From: Amanda Scholes on behalf of Planning.Responses
Sent: 07 December 2017 08:39
To: Planning Scanning
Subject: FW: Planning Consultation on M/121/17/DOC

Surface Water Drainage (Condition no.7) Comments:

APPLICATION NO: M/121/17/DOC

Description of Works: Approval of details reserved by conditions imposed on planning reference M/75/17/PL relating to condition No.5. (materials & finishes), No.6. (Foul & surface water design), No.7 (Surface water design), No.10 (Hard & soft landscaping) & No.11 (Site set up)

Title
AQUAFLOW PERMEABLE PAVING
FORMATION AND CONSTRUCTION DETAILS

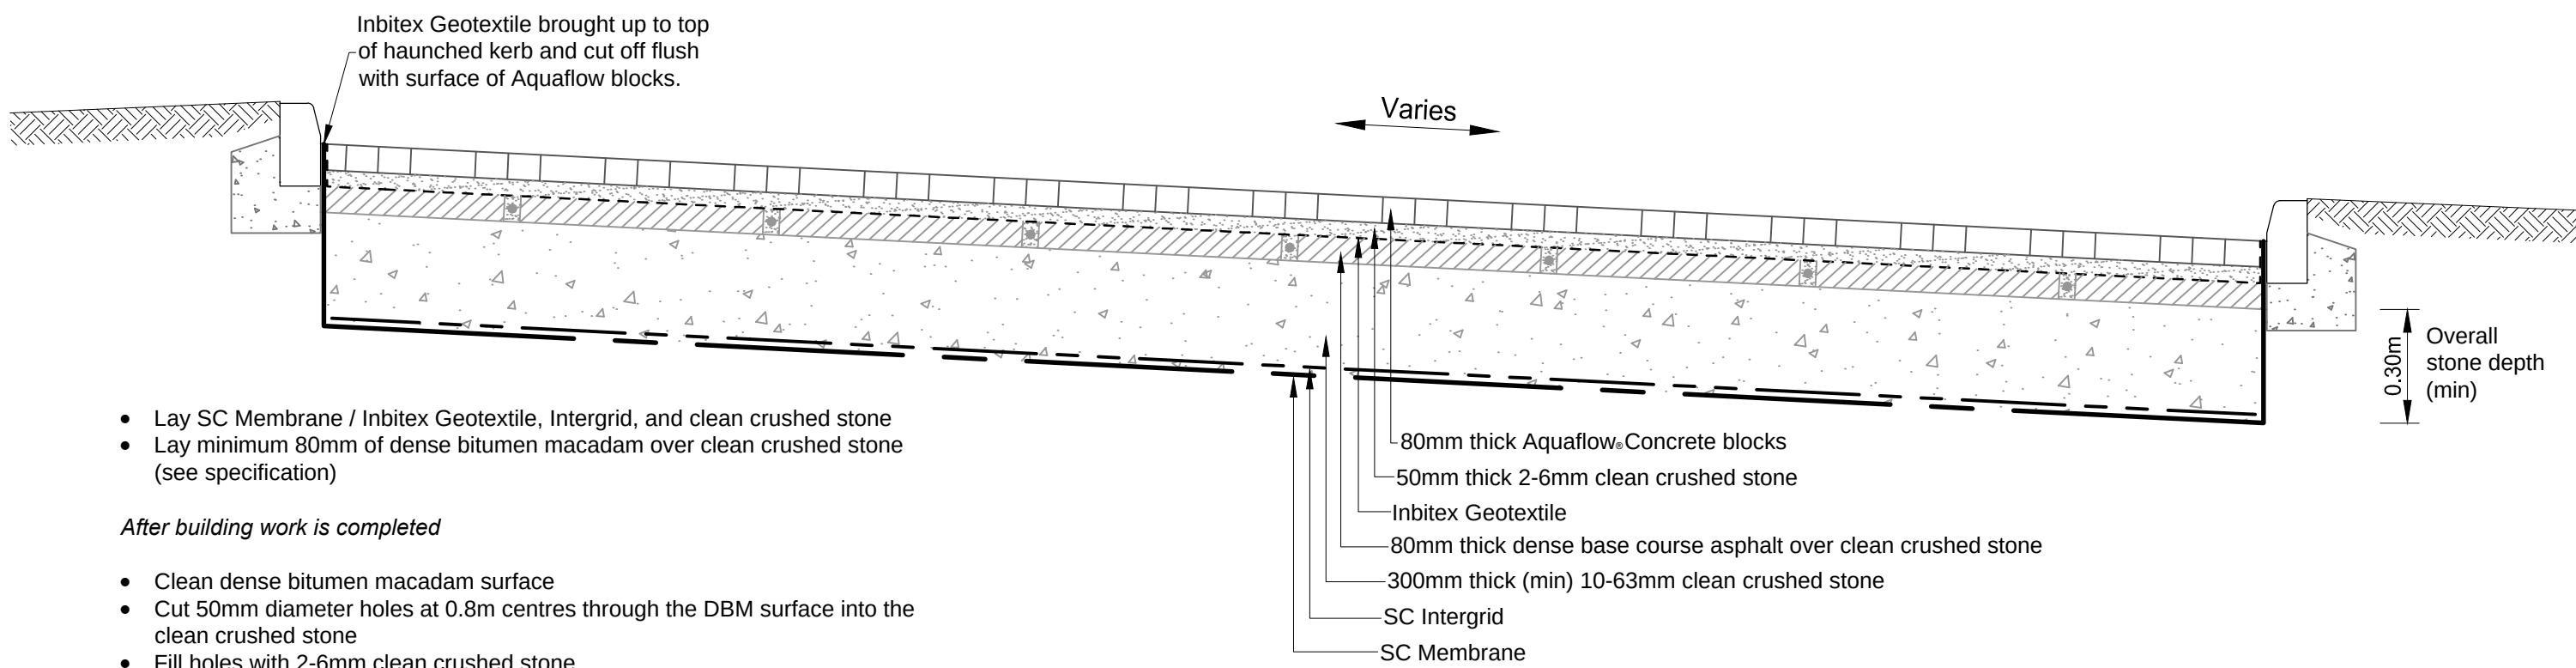
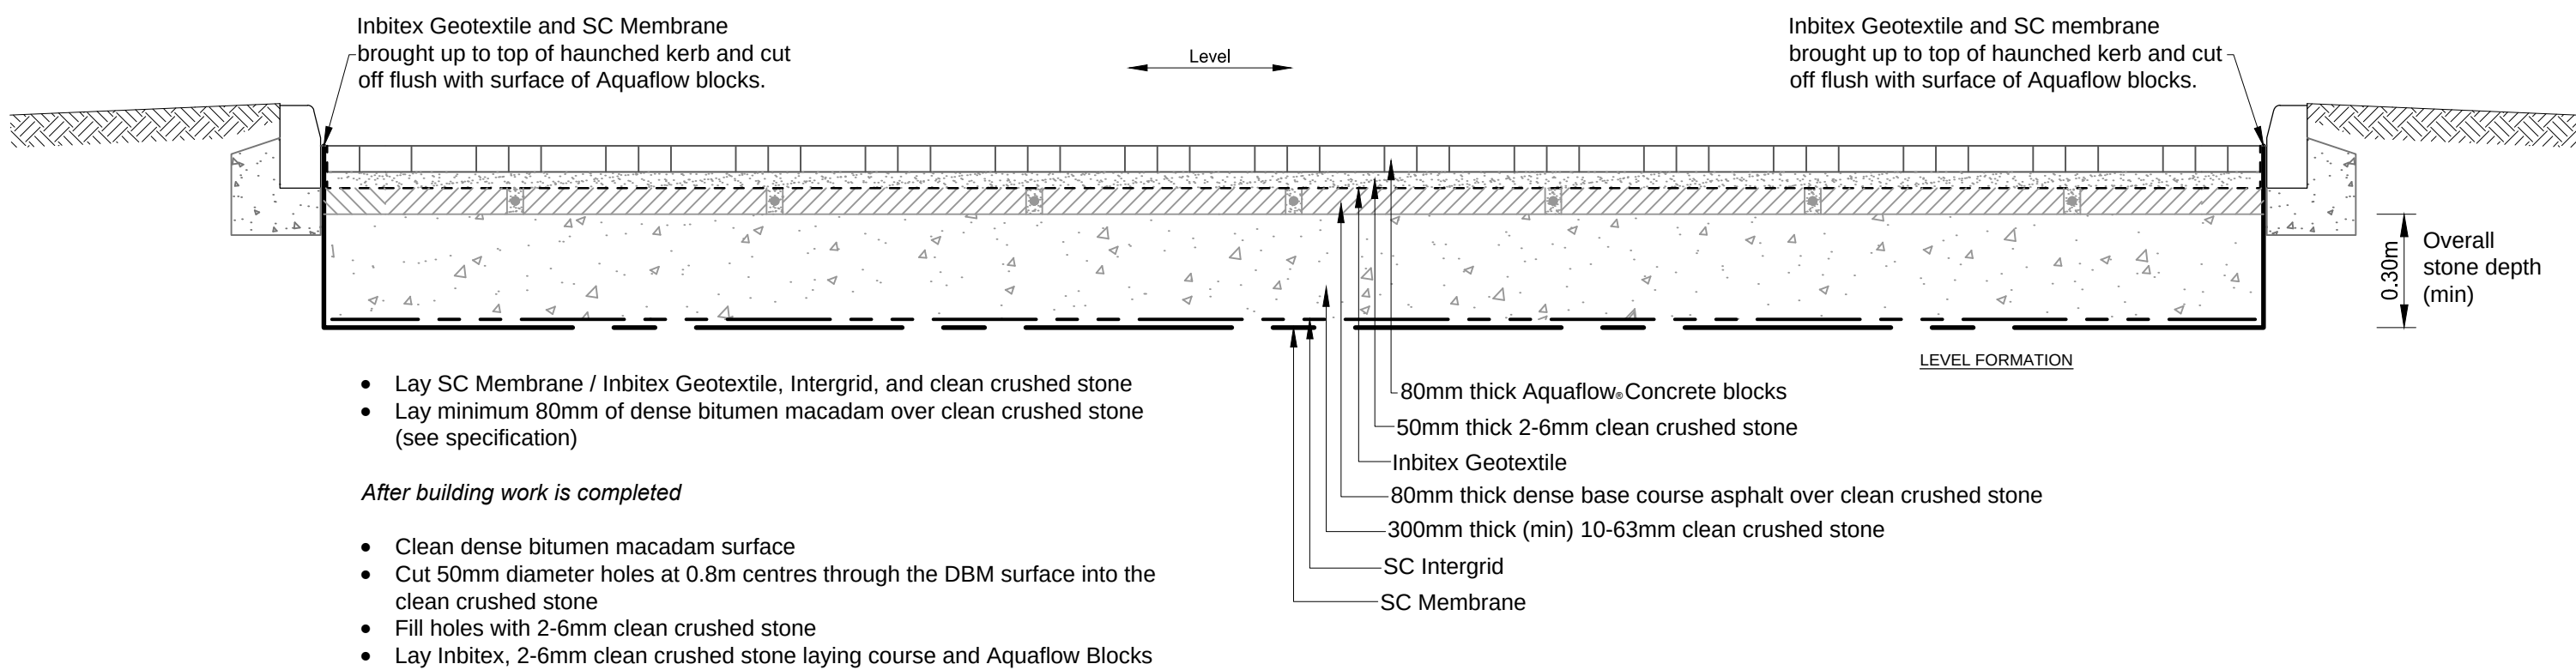
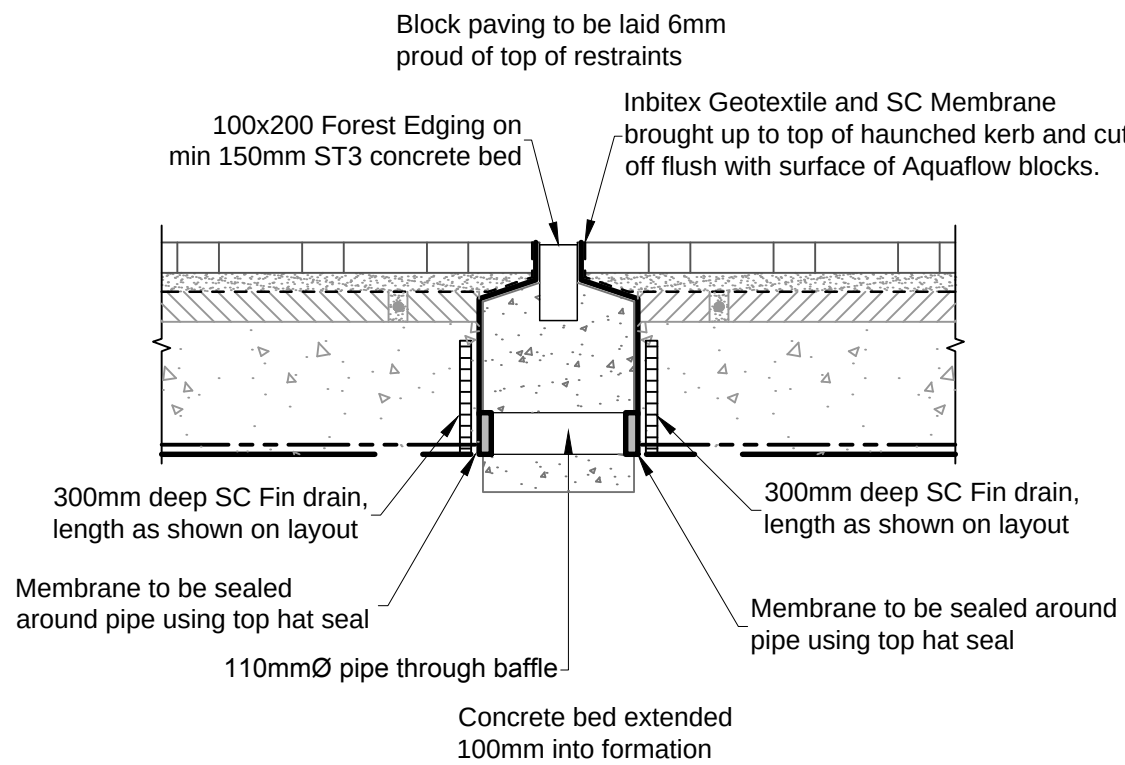
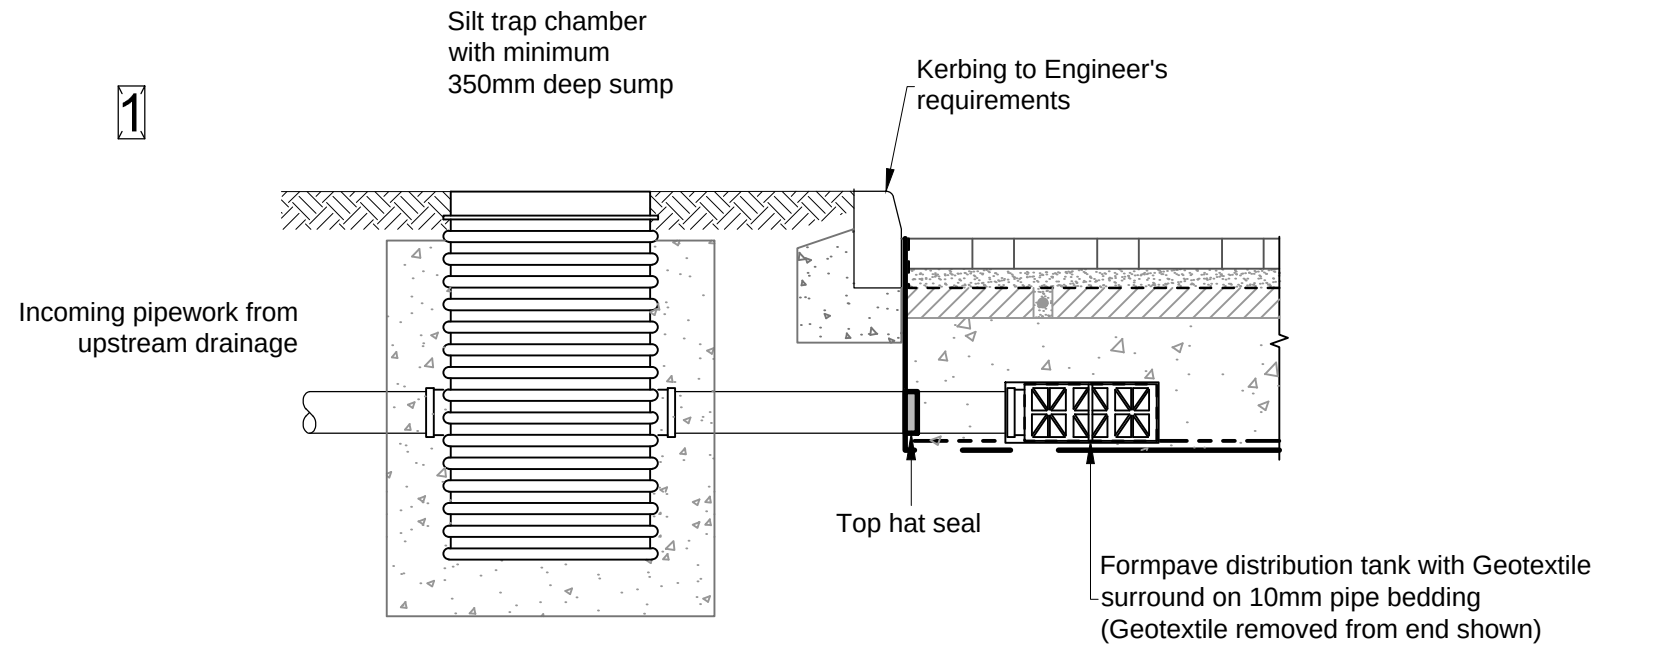
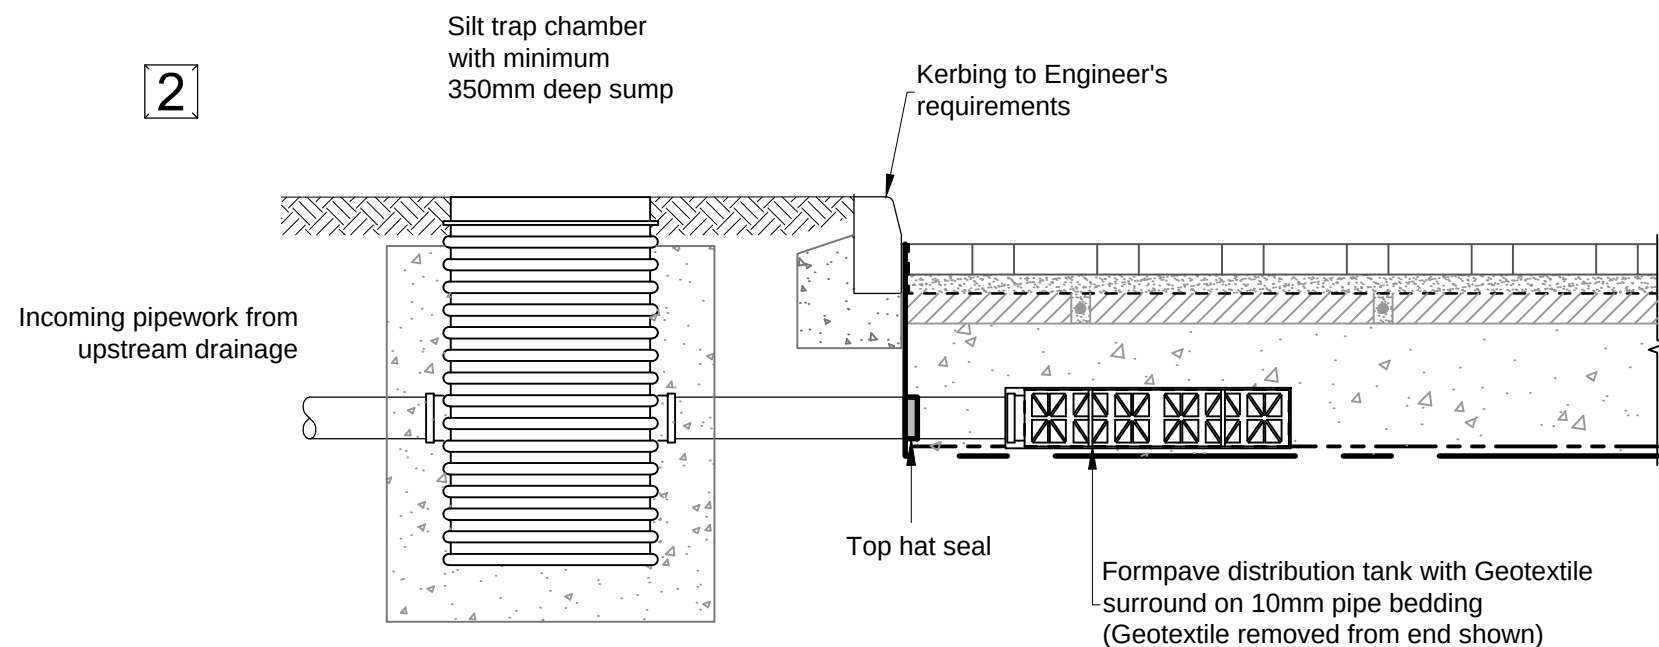
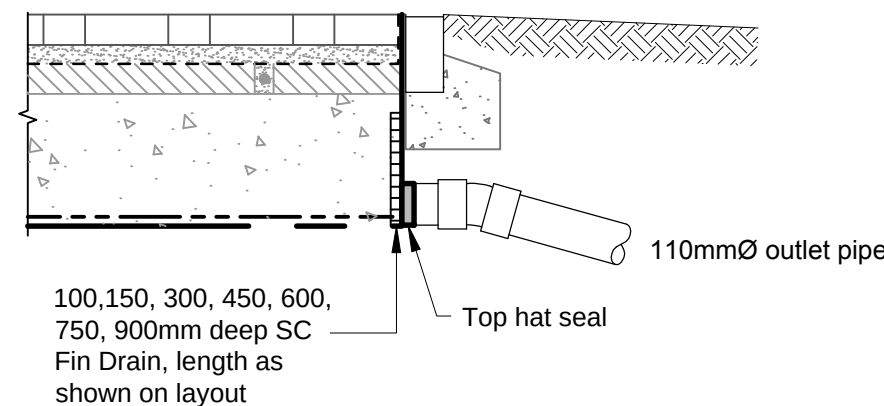
1. Please provide construction details for the orifice flow control chamber & specifying the diameters of all associated incoming/outgoing pipes.
2. Provide detail for outlet arrangement where pipe exits permeable pavement into orifice control chamber ie. formpave distribution tank.
3. Where the existing gullies are being replaced with catchpit manholes – please provide construction details. Note; grated covers to be provided. This construction will also need to be agreed with WSCC.
